# **Application by Rosefield Energyfarm Limited for an order granting development consent for the Rosefield Solar Farm project**

## **Issue Specific Hearing 1**

### ***Comments on behalf of East Claydon Parish Council***

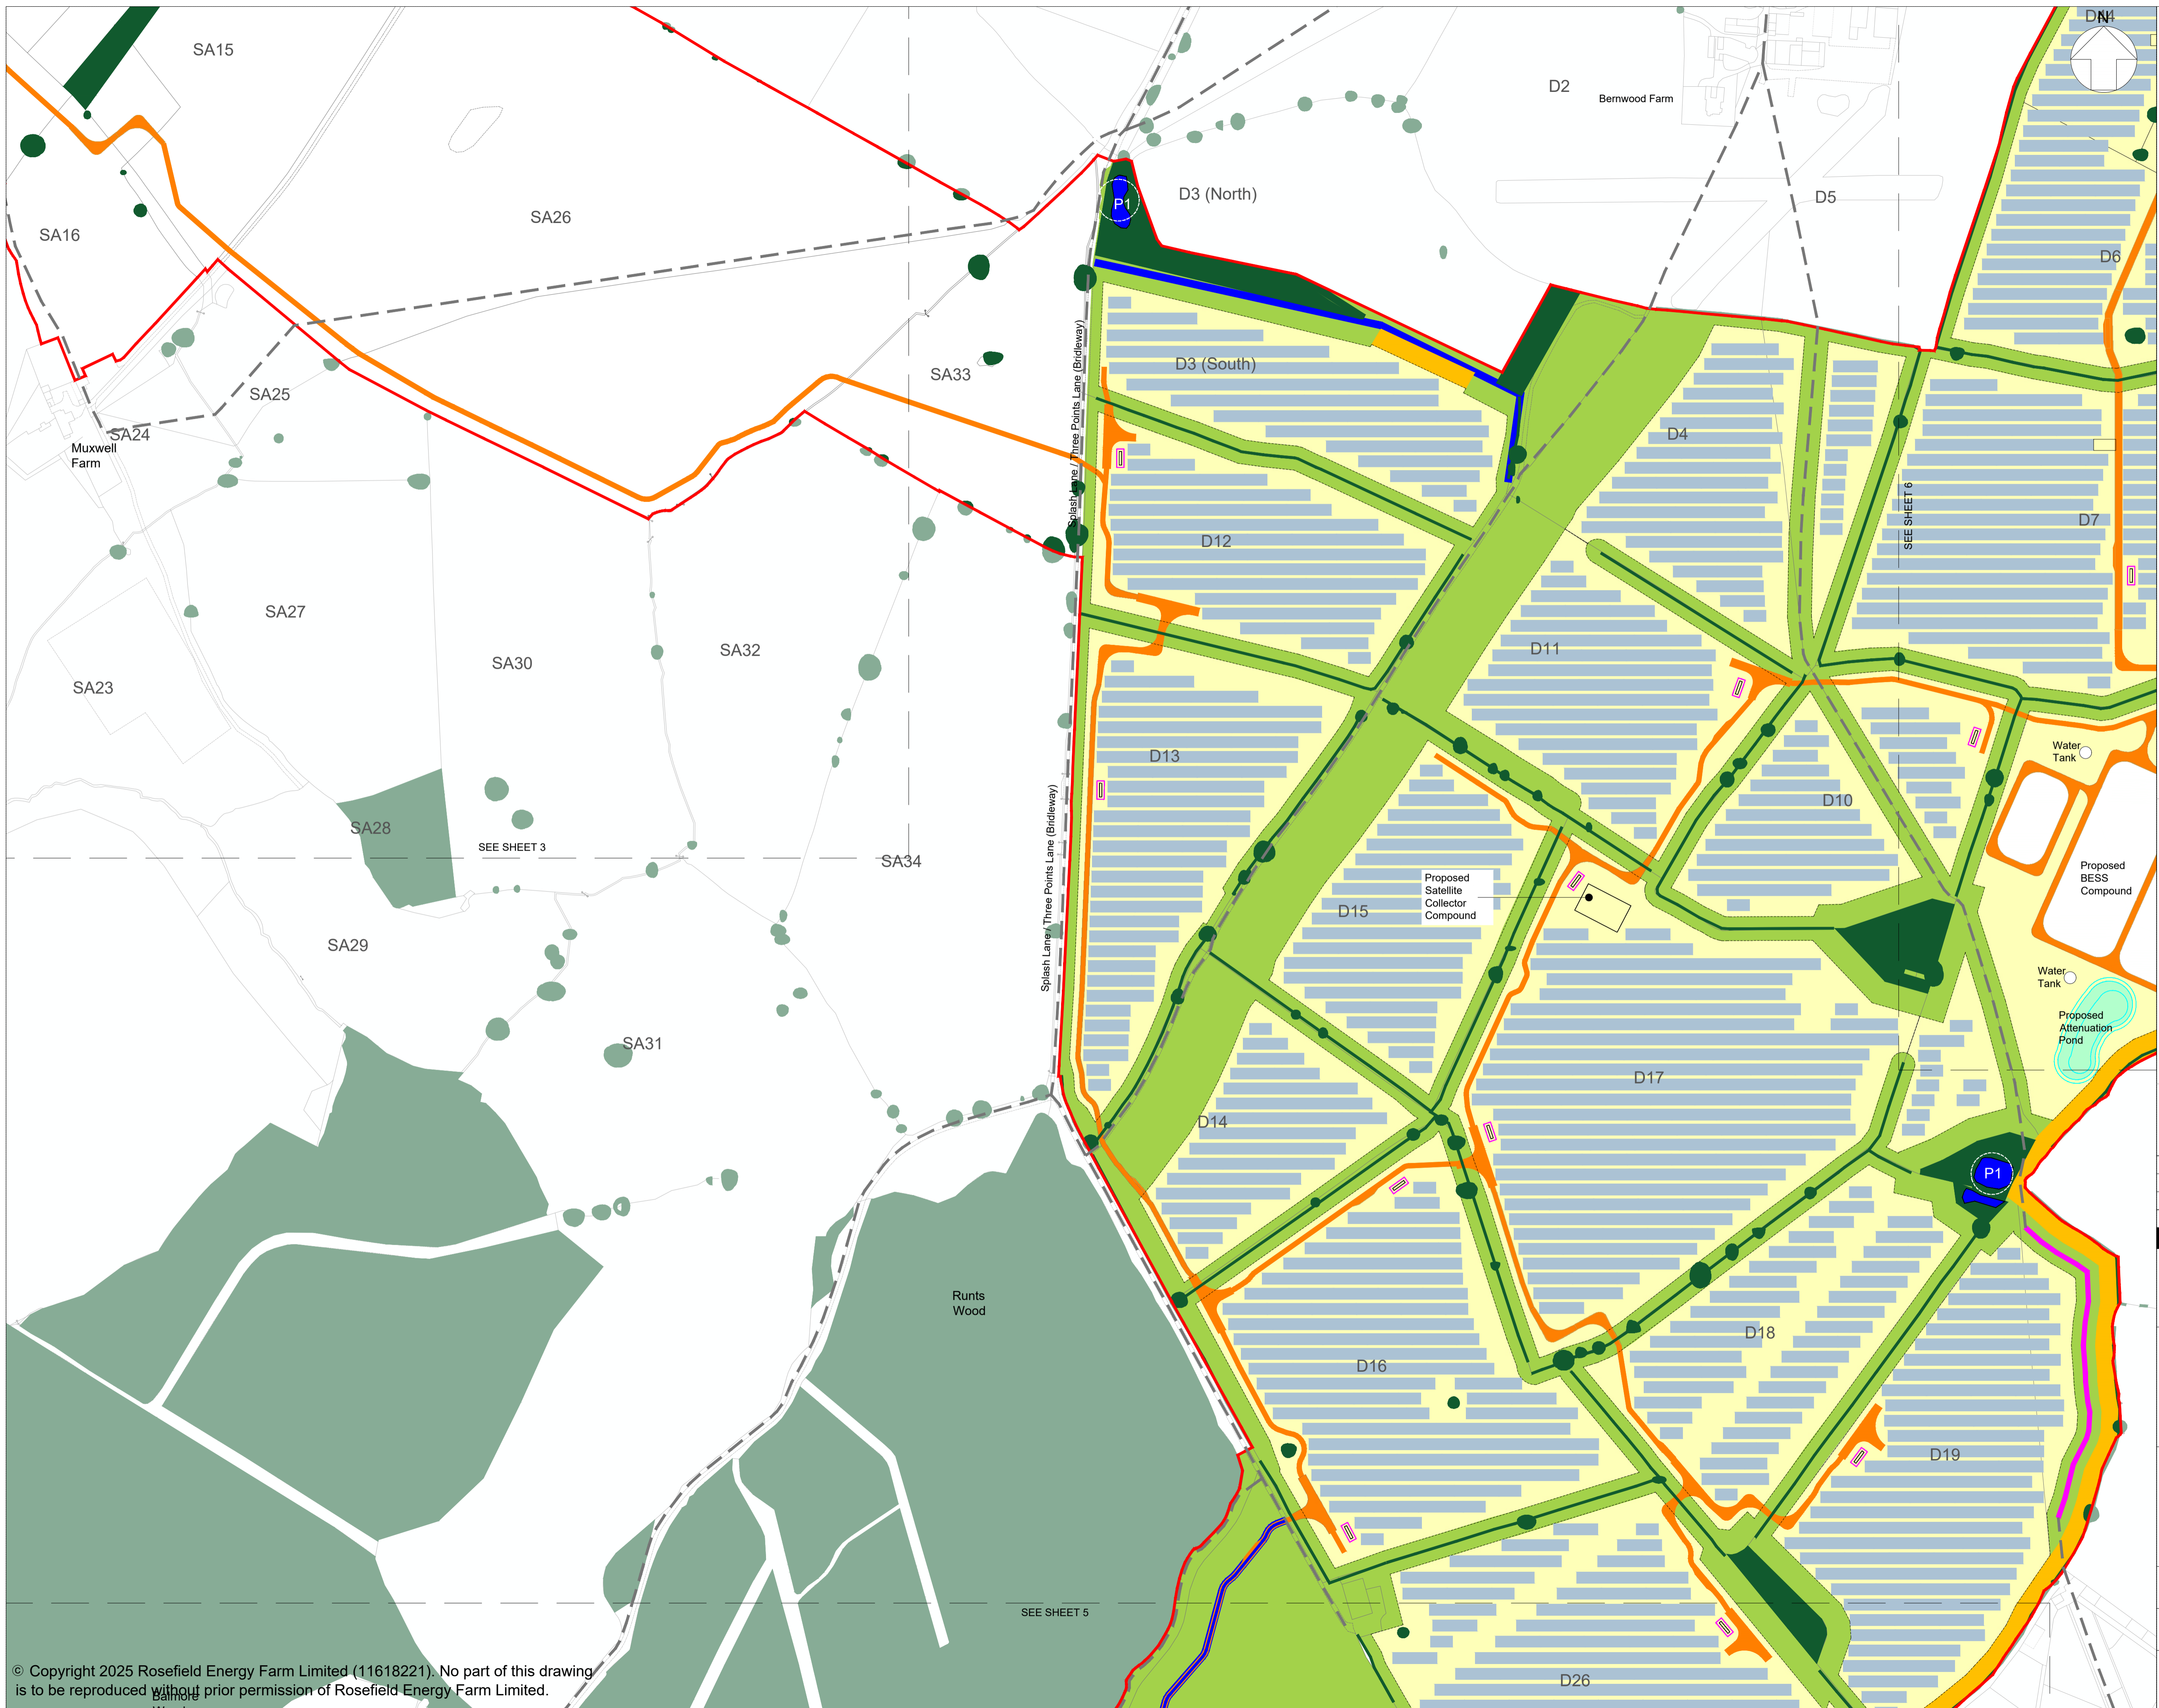
- 4.6 It was noted during the Accompanied Site Inspection that Field SA15 (alongside the drive leading to the Grade II-Listed Muxwell Farm) is one of the best-preserved examples of ridge and furrow field profiles in the area.
- 4.7 The applicant's proposal to traverse this with an access track (as well as ridge and furrow Fields SA16-17 – see figure below) will seriously compromise both the integrity of this asset and the setting of Muxwell Farm which cannot be recovered.

(Left) LIDAR image showing ridge and furrow profiles in Fields SA15-17 [[Aerial Photo Explorer – Over 400,000 aerial photos in Historic England's digitised collections | Historic England](#)]; (Right) Illustrative Layout Plans and Drawings Sheet 3 of 9 (REP1-007). Proposed internal track shown in brown.
